Your ref CONCS/3/2007/0954  
 Our ref TS/D3/07/954/MRN (VF)  
 Date 25 October 2007

**TOWN AND COUNTRY PLANNING ACT 1990  
 PROPOSED CHANGE OF USE OF HOLIDAY COTTAGES TO RETIREMENT  
 ACCOMMODATION  
 GREENBANK FARM WHALLEY ROAD SABDEN  
 FOR G GREENWOOD**

GREENBANK COTTAGES - WHALLEY ROAD - SABDEN

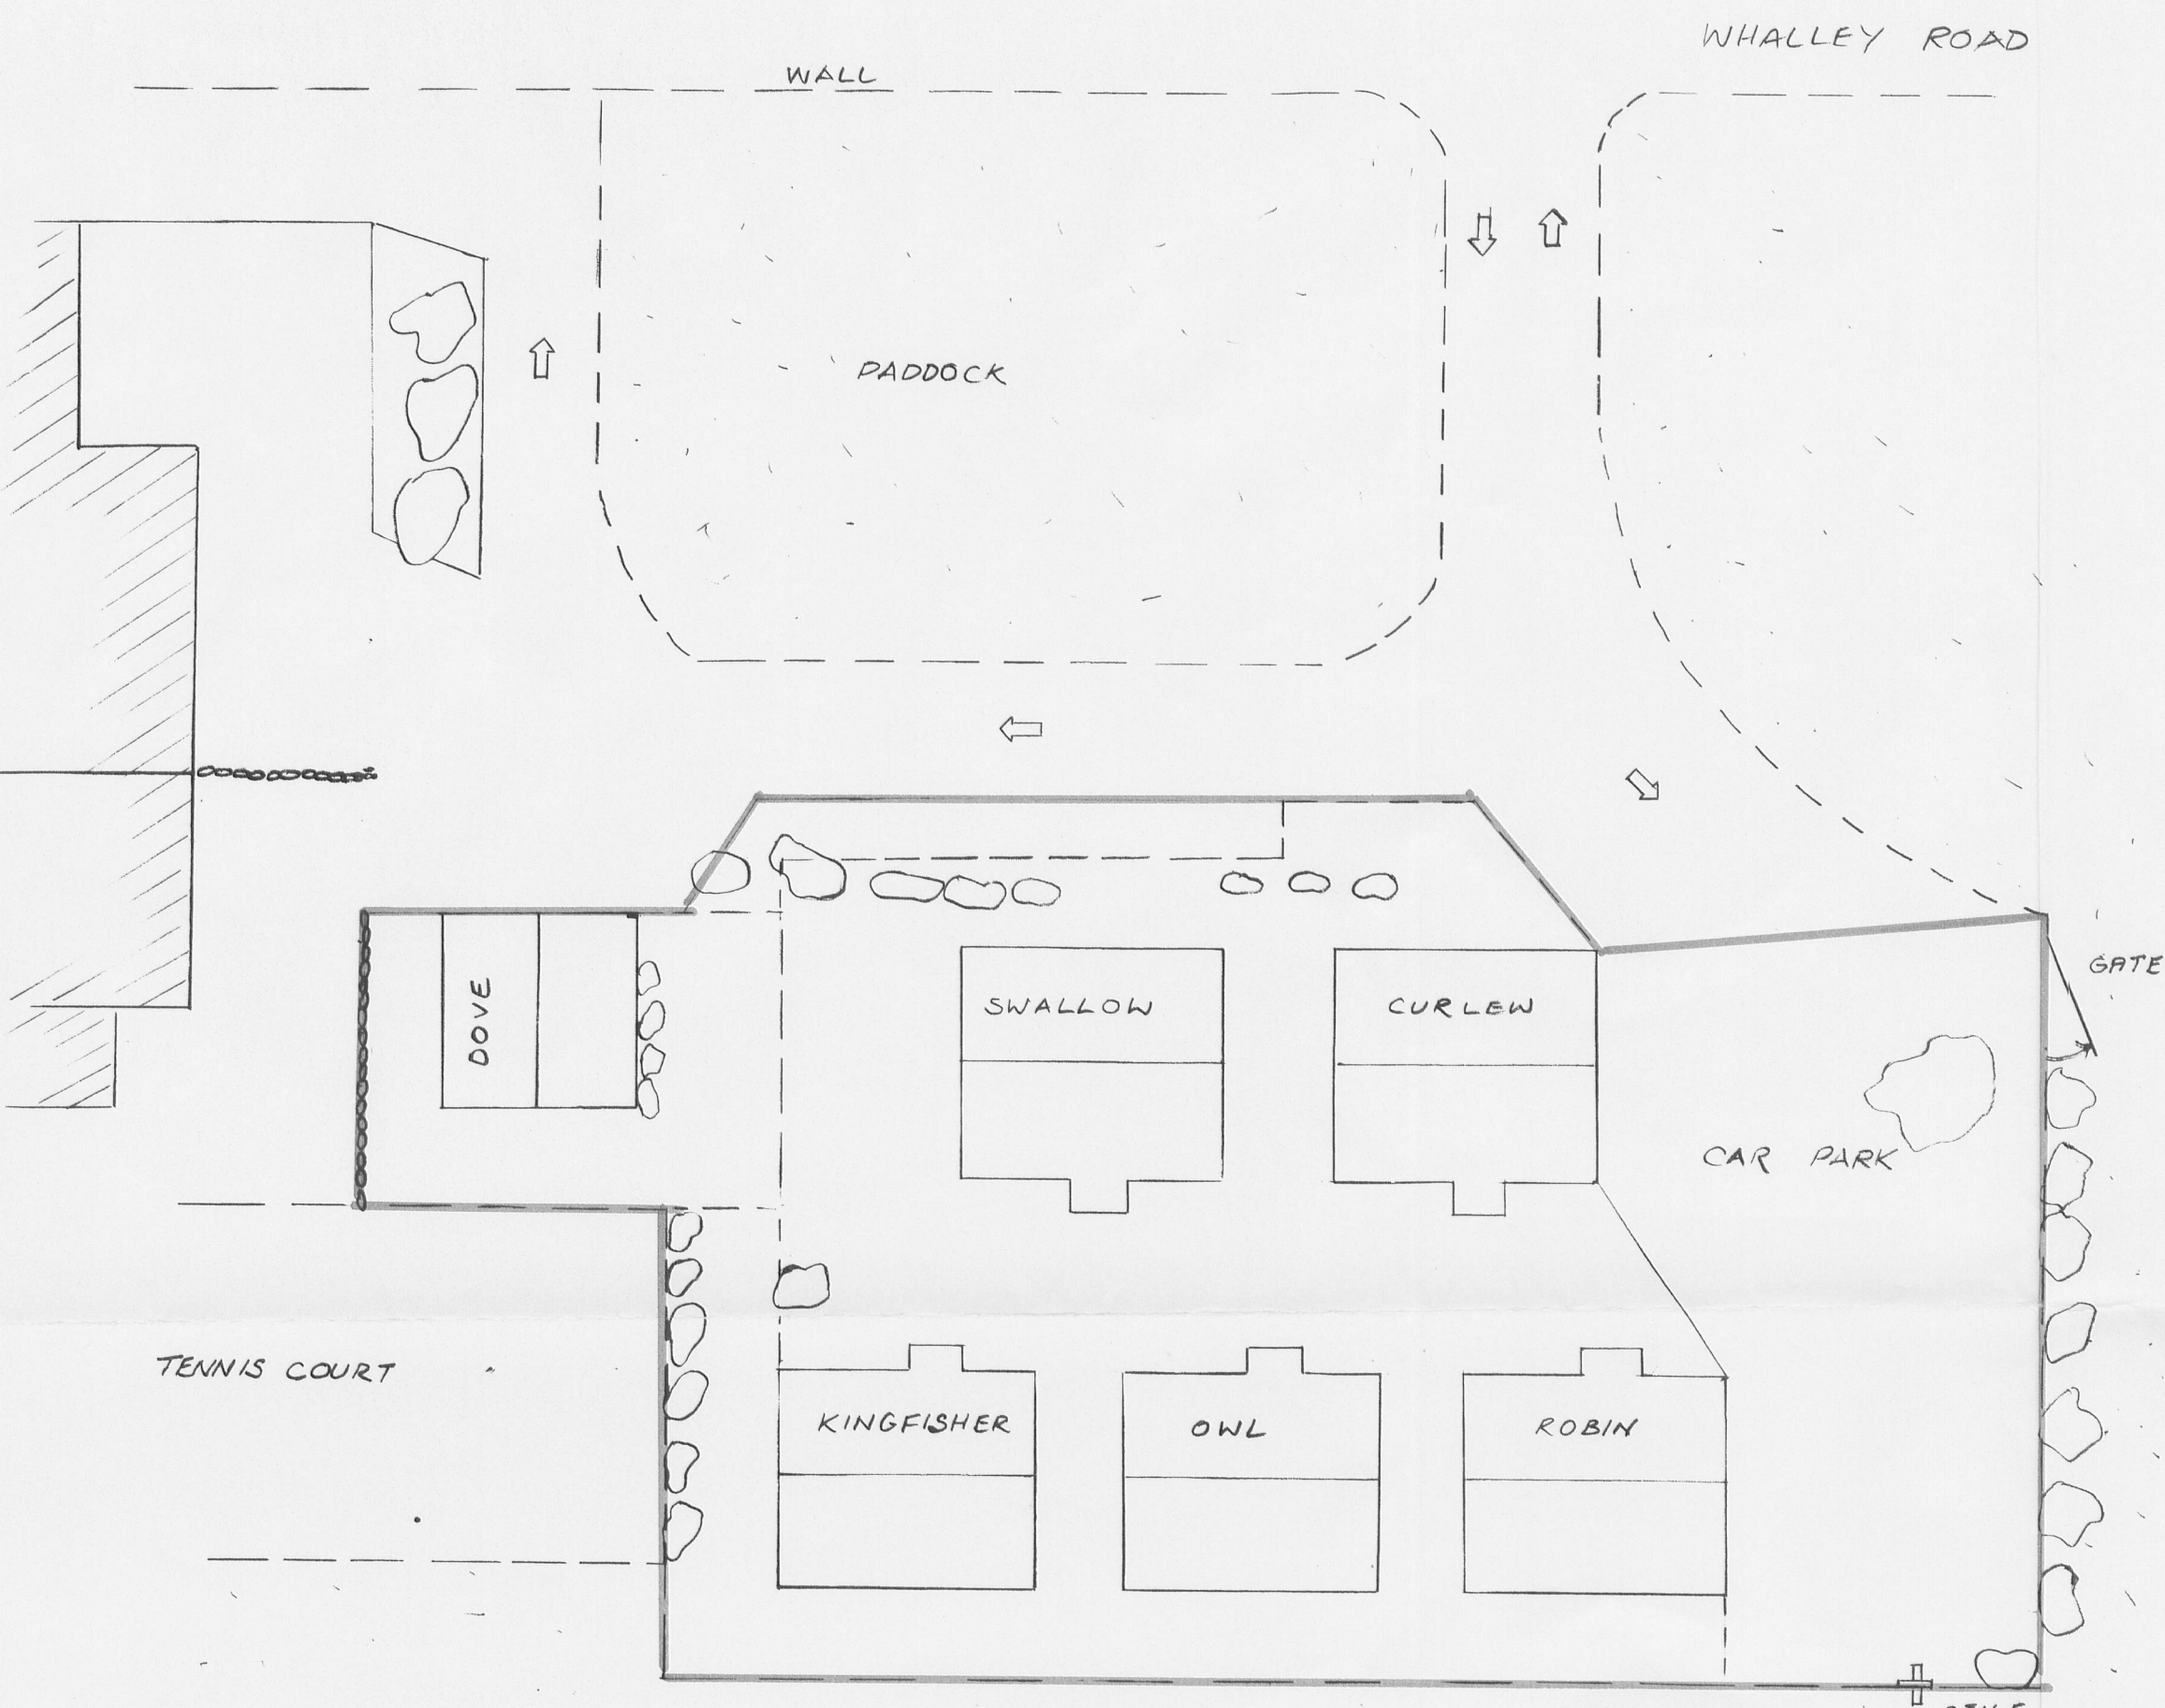
The existing access provides adequate visibility in either direction and is constructed to a good standard. In order to avoid confusion, I would suggest that the direction arrows on the site plan are amended to show the correct direction of travel.
